DECISION DELEGATED TO HEAD OF PLANNING

Application No: H09-1041-25 **Applicant:** Mr S Hassan

Proposal: Change of use part of existing Car Wash into Car Wash and Tyre Fitters (Sui Generis Use) (Retrospective)

Location: Jewson Ltd Boston Road South Holbeach

SCALE: 1/200 @A3	REF. NO :BST34/24/01
DATE: MAY. 2025	DRG BY: B.OZDEMIR

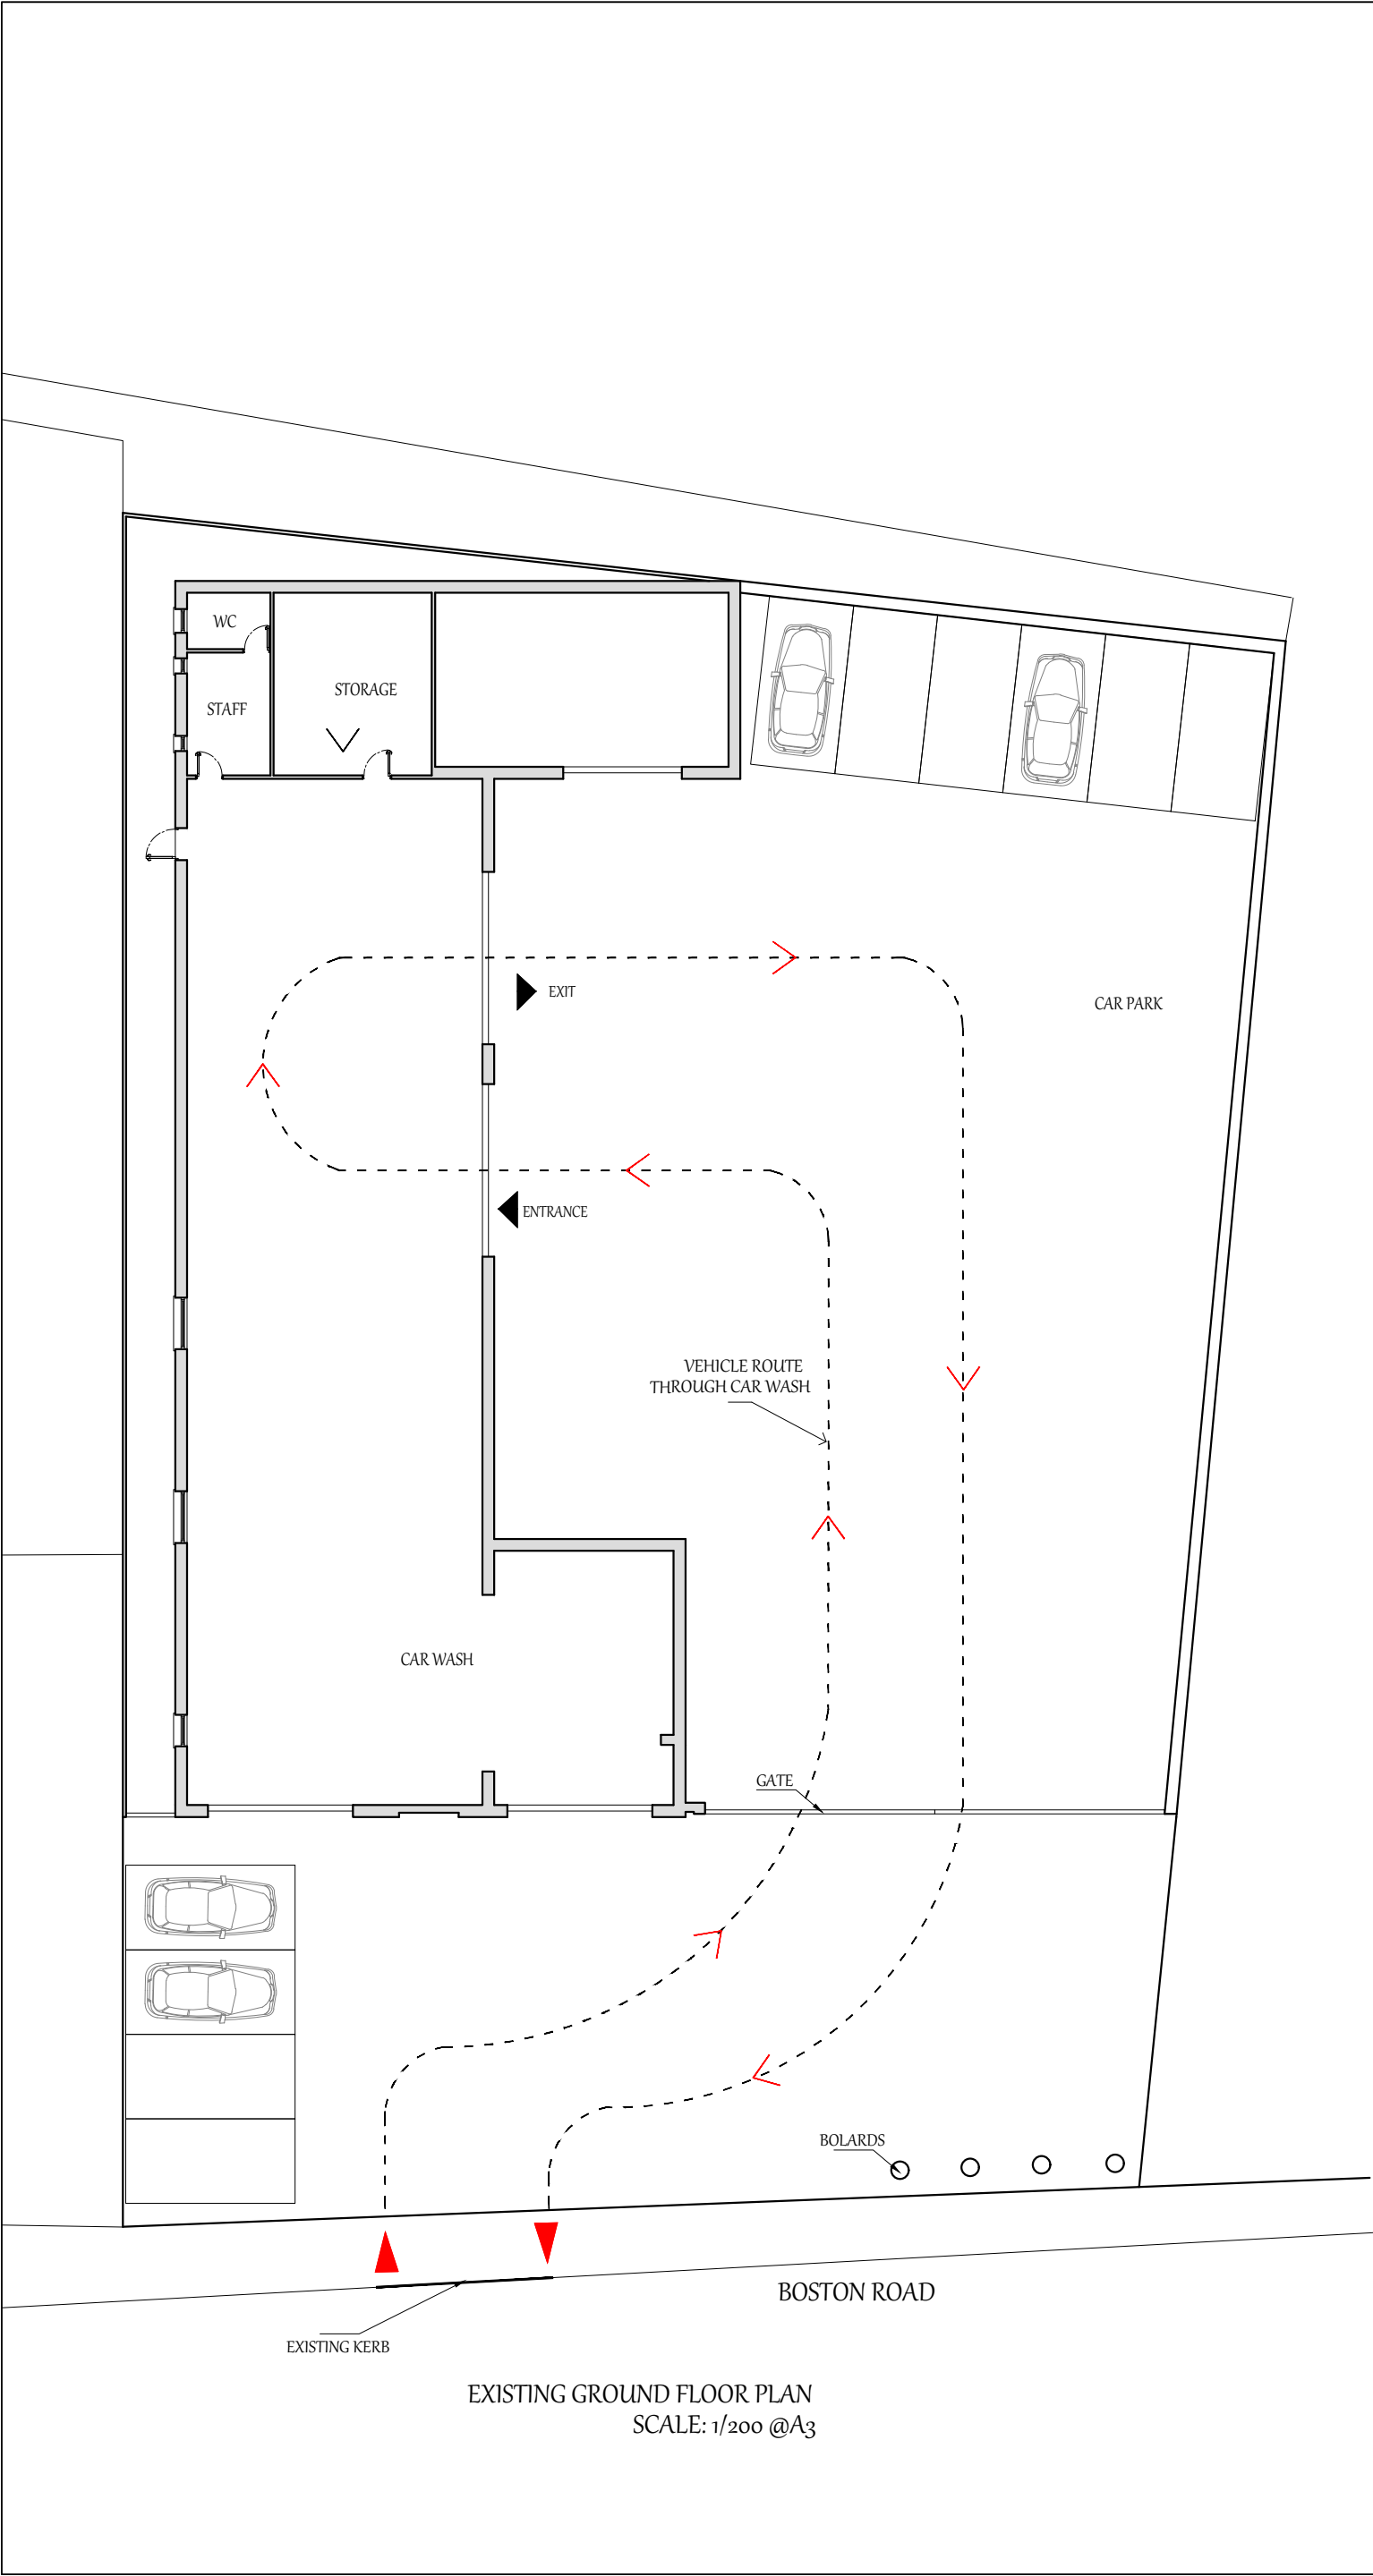
- The application form sets out that no hazardous substances will be used; however, this is incorrect.
- The document BST34/24/01 Existing Site Plan, Ground Floor Plan is incorrect . The traffic flow is currently through the building and out through the front area which is the proposed Tyre bay entrance and exit

- The new proposed route for the car wash queue, blocks car parking for the restaurant and tyre bay parking during busy times, and likely to extend out onto the road. I have concerns for pedestrians from the restaurant.

The site layout remains unchanged from the approved layout under permission H09-0563-25. 19 parking spaces are shown throughout the site. These spaces are proposed to accommodate the car wash business, the tyre fitting business and the hot food takeaway within the site. Lincolnshire County Council's highways team have not raised any objections to the proposed number of parking spaces. The access arrangements will also remain unchanged.
